Your Ref :
Our Ref : R/79/18/NMA

**Section 96A of the Town & Country Planning Act 1990 (as amended)
Town and Country Planning (Development Management Procedure) (England) Order 2015 (as amended) - Article 10**

**Application for a non-material amendment following a grant of planning permission R/14/17/HH relating to the removal of 2 side velux windows and install 1 x 1m x 2m flat glass roof light well
8 The Martlets, Rustington, ,**

BAR SCALE (METRES)
SCALE 1:100@A3 DRAWN 1A APR 10
DRG No. 16212 P 01

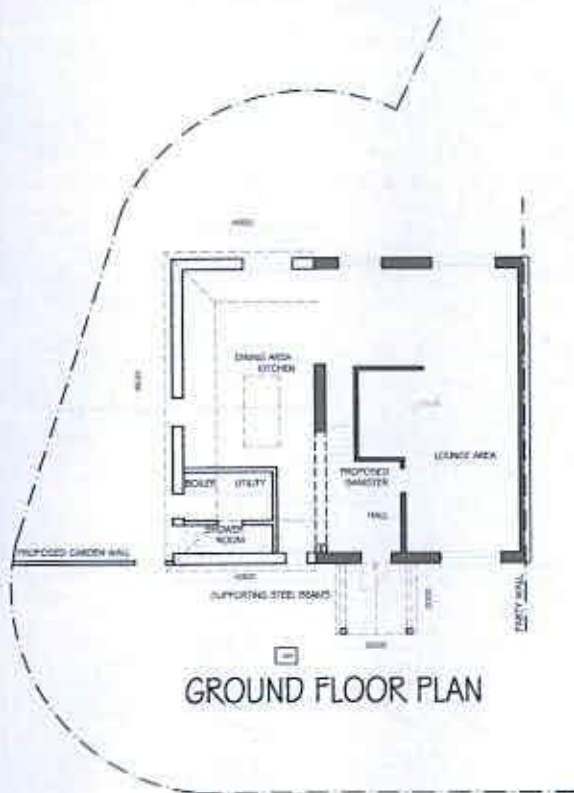
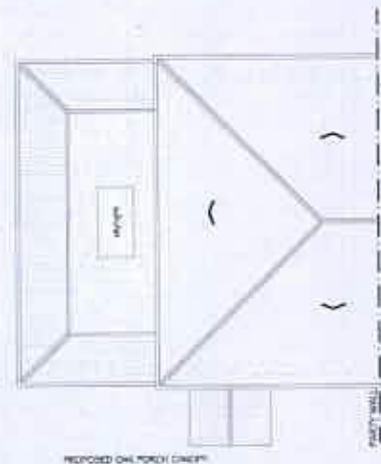
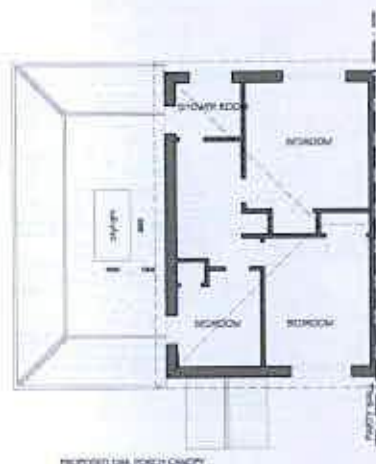
- Alter the roof shape of the extension lowering the peak roof height from 4.3 metres to 3.8 metres and increasing the size of the flat roof at ridge height thereby decreasing the hips of the roof.
- Replacement of 2 side velux windows in the side hip of the roof of the proposed extension with a single 1m x 2m flat glass roof light well on the flat area at ridge height.
